73 STE-CECILE STREET

DESIGN BRIEF

19 December 2024

RESPONSES TO URBAN DESIGN COMMENTS FROM THE PRE-APPLICATION CONSULTATION

SOUTH ELEVATION

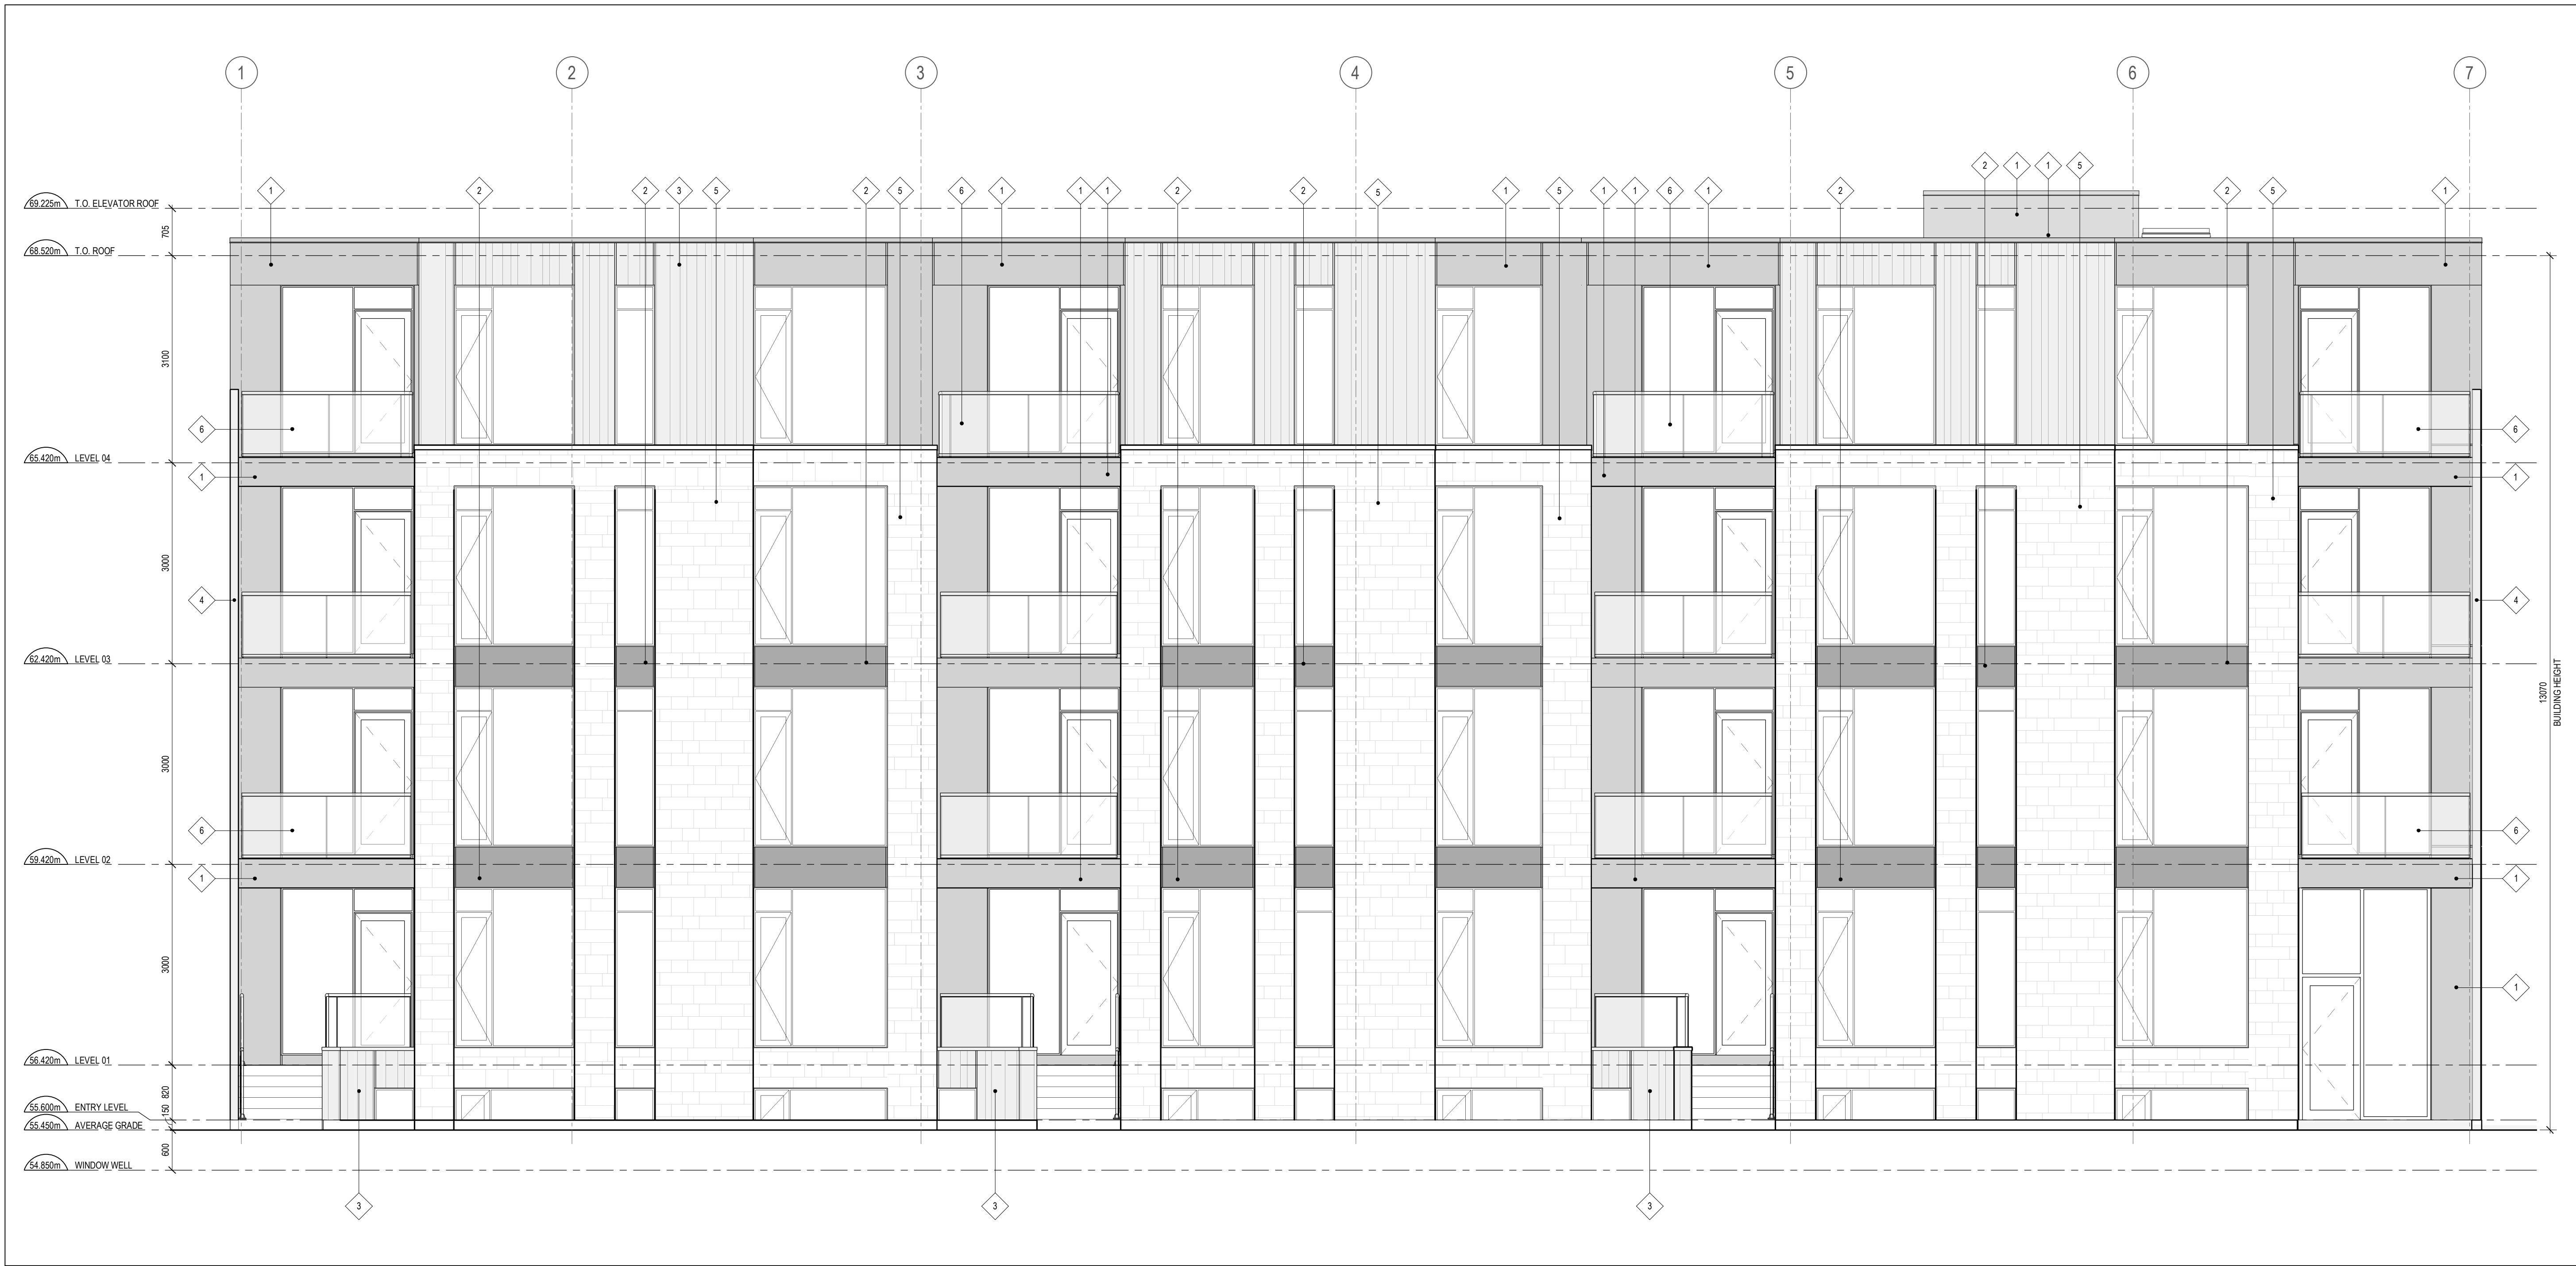
Building height – To help mitigate the impact of the additional 2.6m in height, we recommend setting the top floor back by 1.5m from the front facade. In addition, removing the roof that covers the top floor balconies may assist in reducing the impact of the additional height and massing.

The original design of the building had the top floor set back 0.3m, and the design has been revised to provide a step back of 0.75m at the top floor. The design of the building now has 48% of the front elevation setback from the front wall of the building by at least 0.75m. We feel that this revision to the design provides sufficient transition to mitigate the additional building height being requested.

DRAWING NAME
LANDSCAPE PLAN

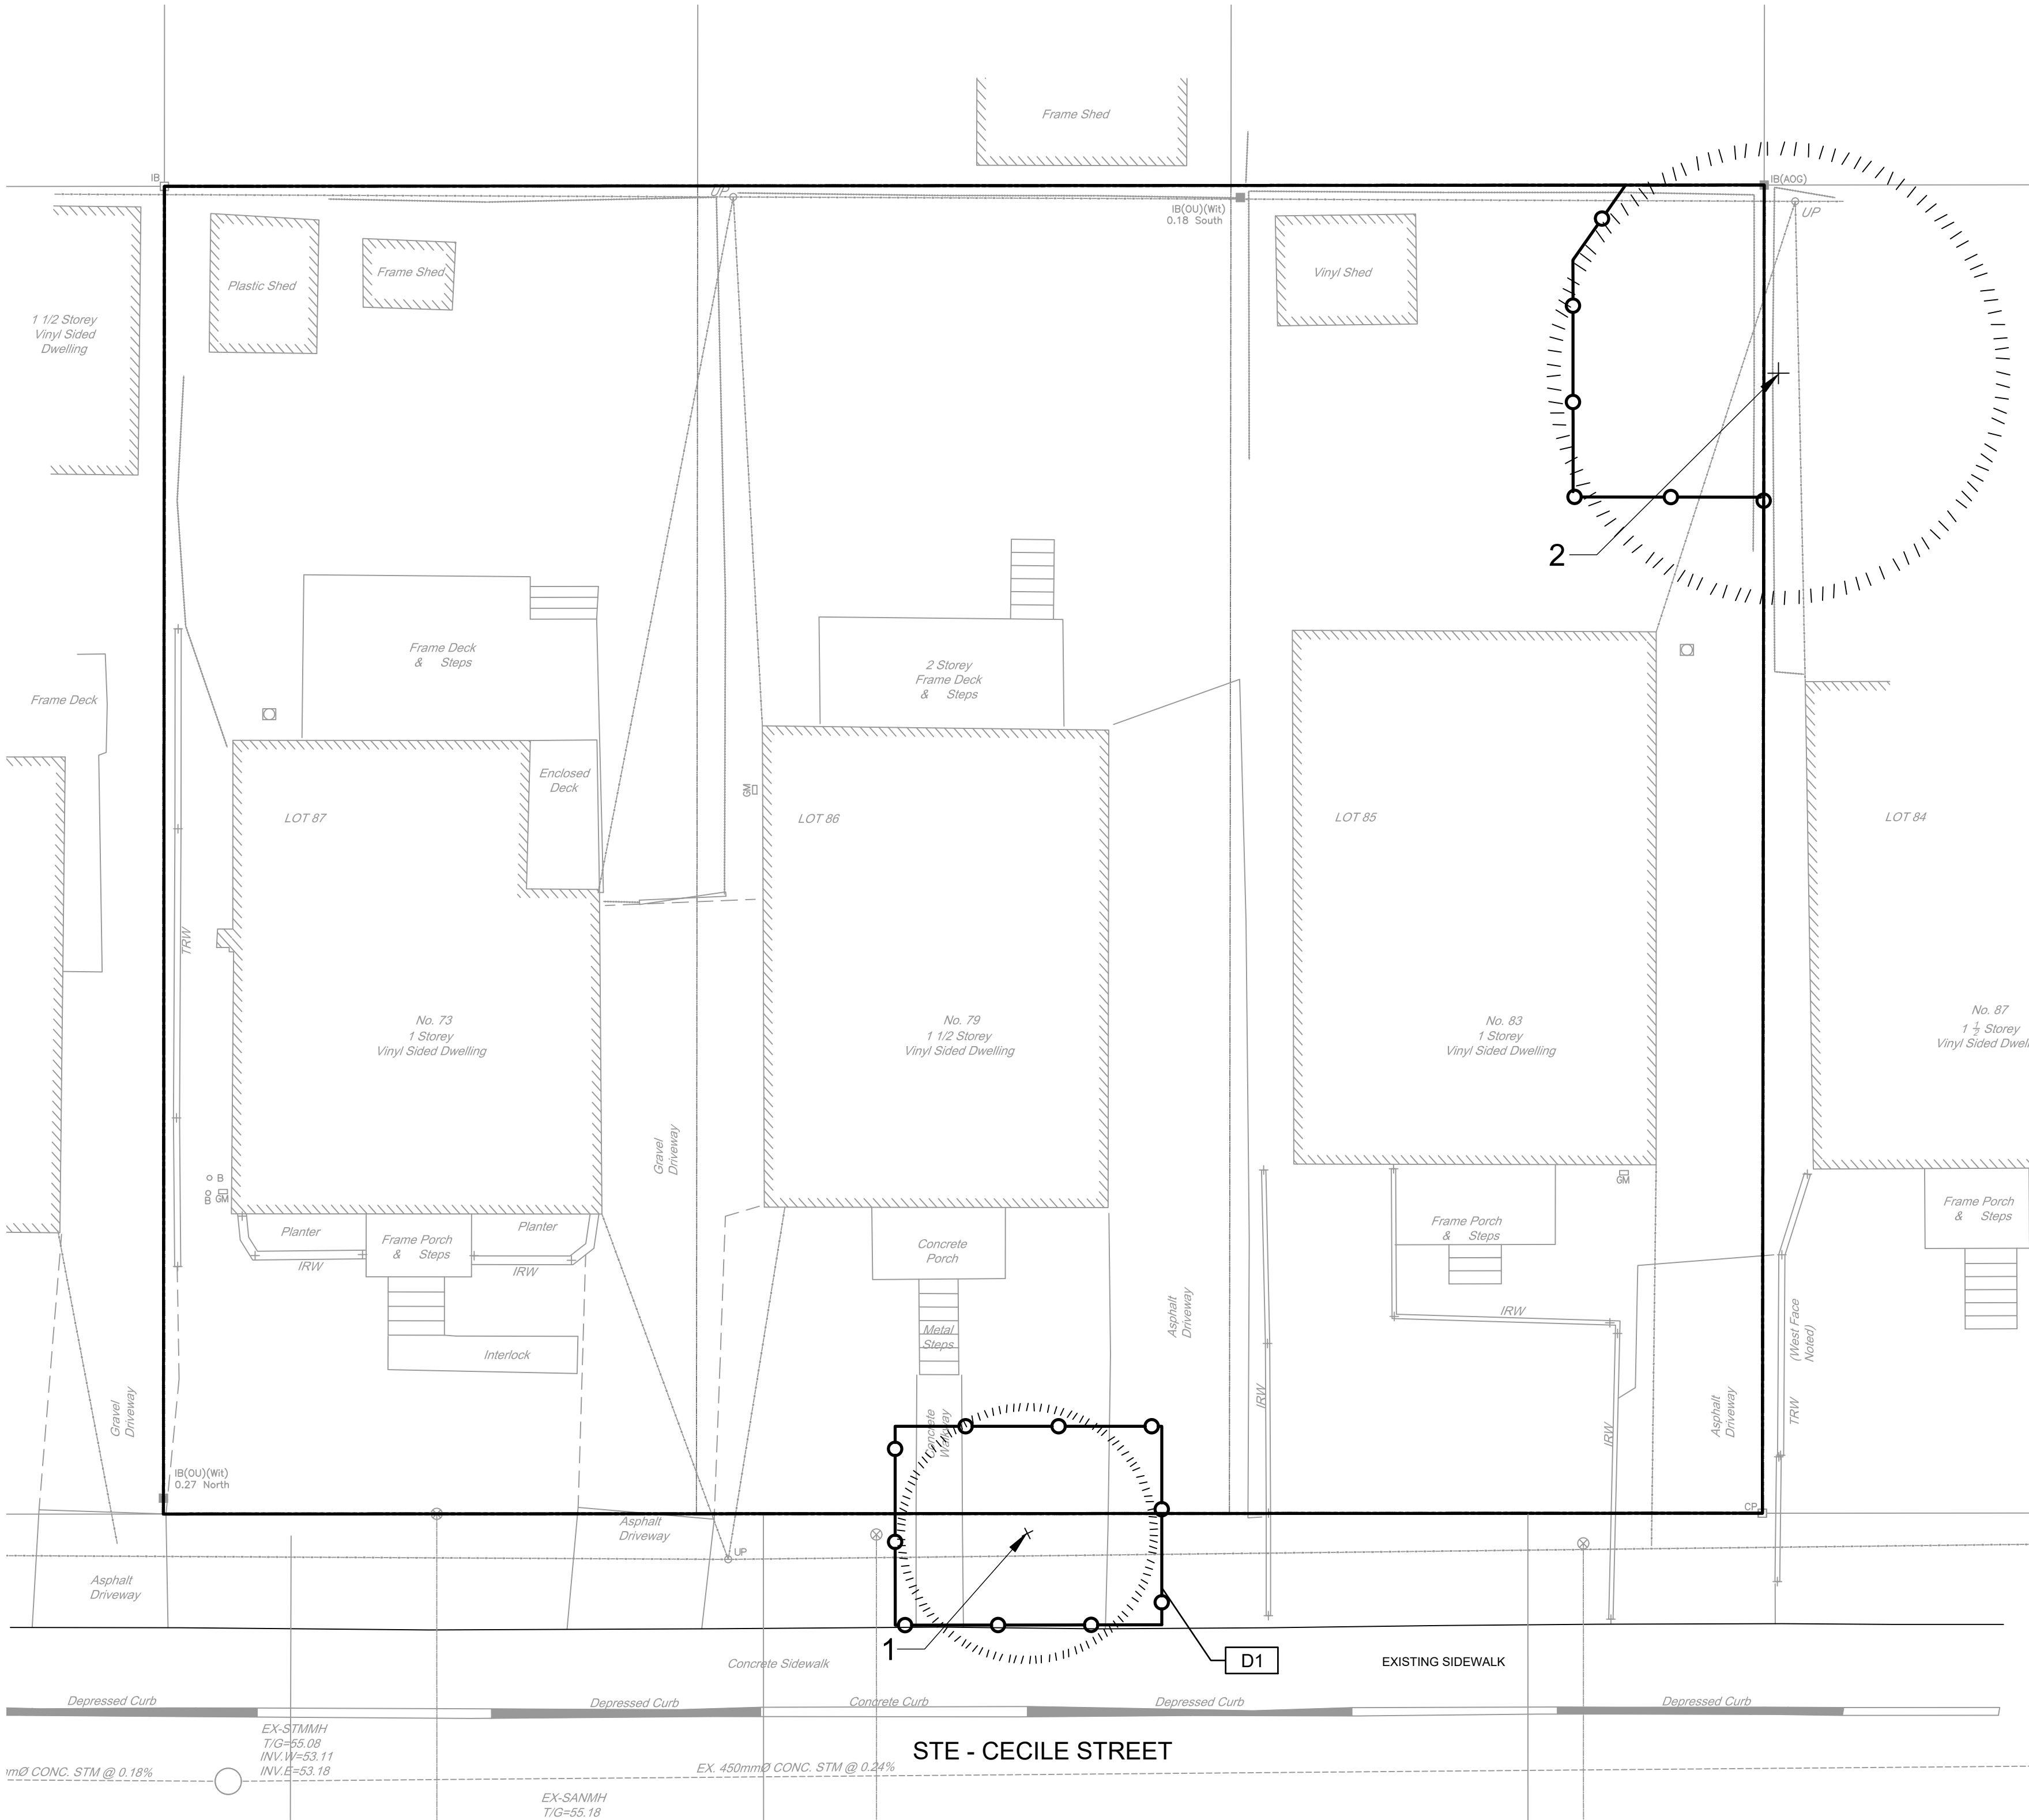
Landscape requirements – The Zoning by-law requires 30% of the total lot to be landscaped and 40% of the front yard to have soft landscaping. It is unclear if these percentages are being met. The applicant is asked to provide a drawing which demonstrates that the provisions of the by-law have been met.

Bike parking – All required bike parking/storage for residents should be located internal and/or in the rear yard where it is weather protected and hidden from the right-of-way. If bike parking is located in the front yard, it should be reserved for visitors only.

Tree planting is required. The landscape plan should show 4 trees in the front yard and 3-4 trees in the rear yard.

The revised site plan provides an updated table showing that the front yard soft landscaping is at 53%, and this does not include the area occupied by planters. The rear yard soft landscaping is at 78%.

Bike parking is provided for the project at a ratio of 1:1, and is comprised of 36 indoor spaces and 6 outdoor spaces that are covered and are in the rear yard.

Noted, please refer to the landscape plan for details on tree planting
